To: All Staff
From: Environmental Health
Date: December 29, 2025
Subject: BL-25-00020 Martin

MARTIN BLA SITE PLAN

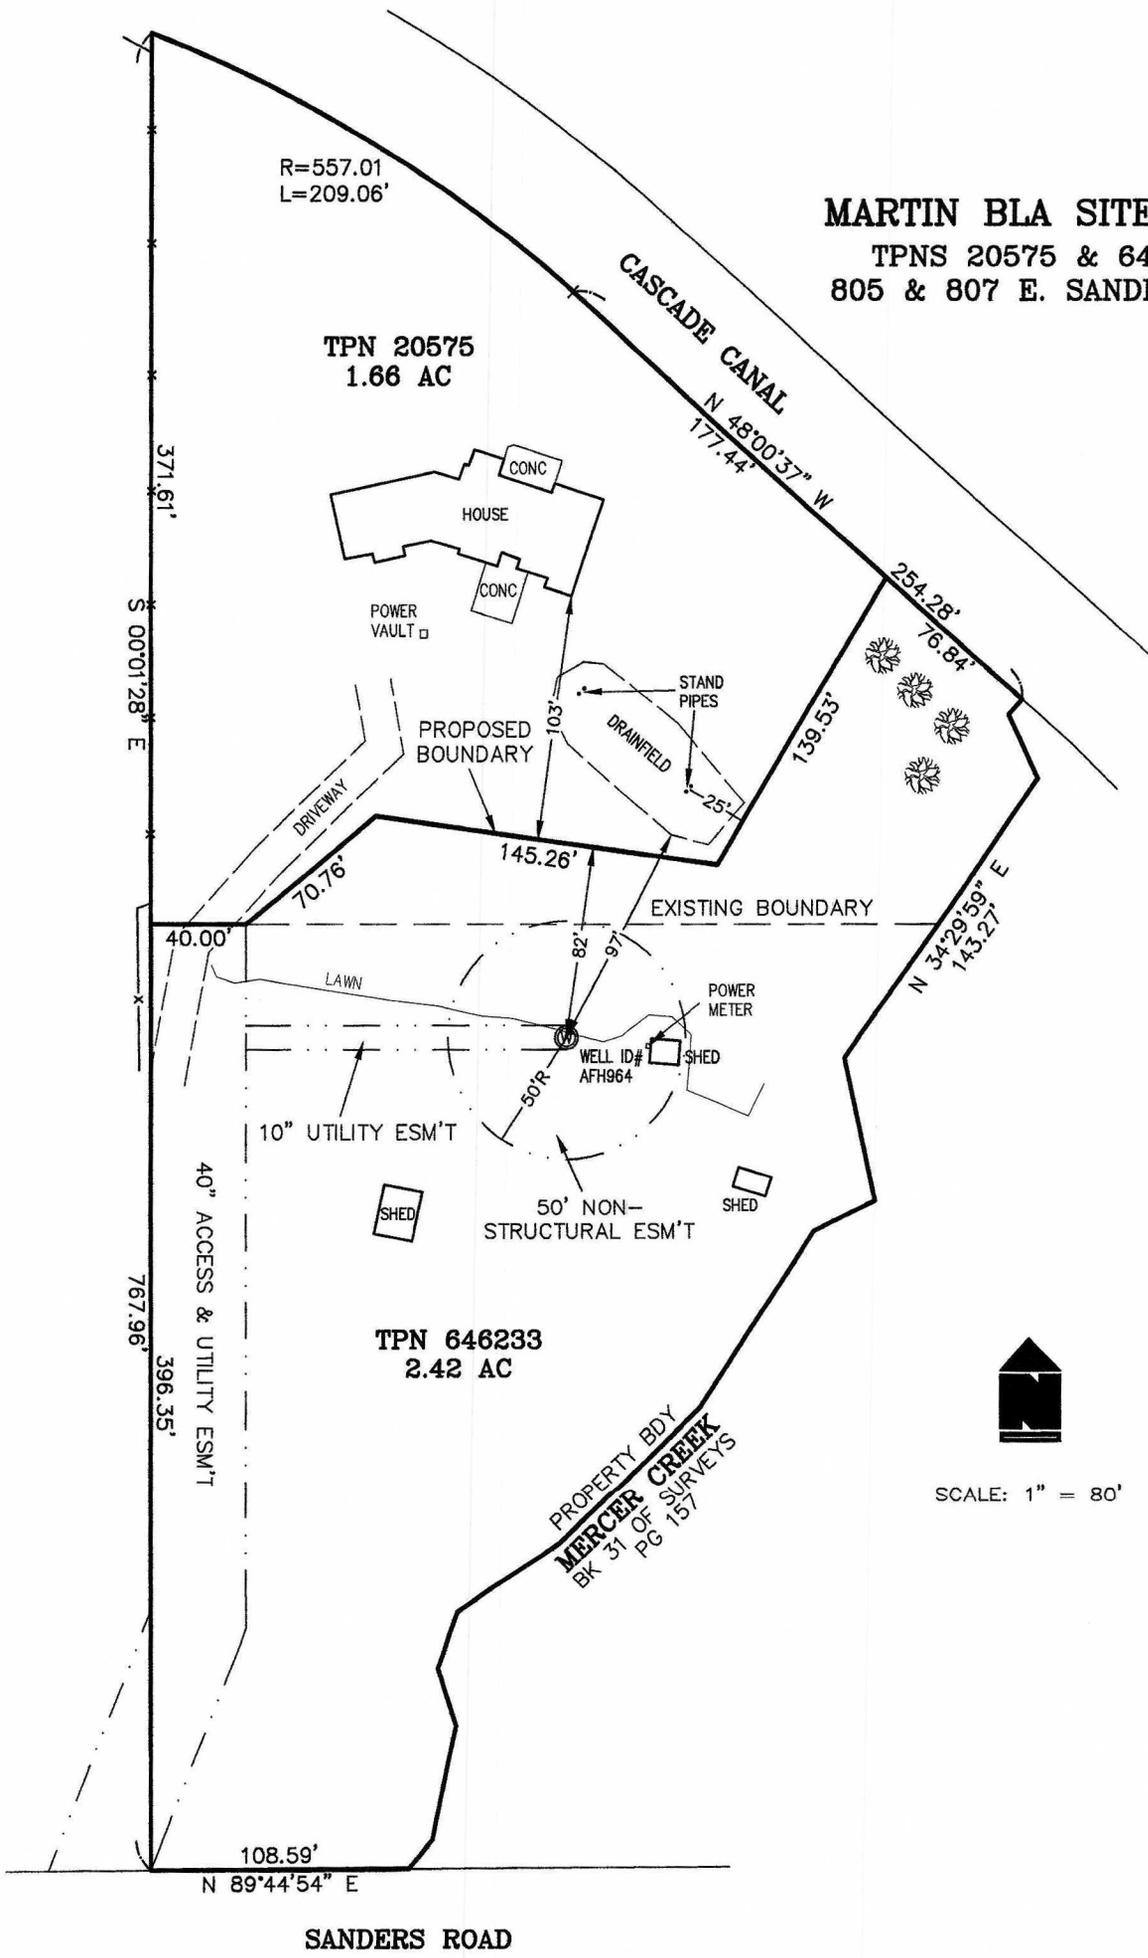
Drinking Water	<ul style="list-style-type: none">• No comment for boundary line adjustment.
Wastewater	<ul style="list-style-type: none">• Provide updated on site septic as-built verifying property lines are a minimum of 5 feet from the edge of the current mound system filter media and include reserve area location
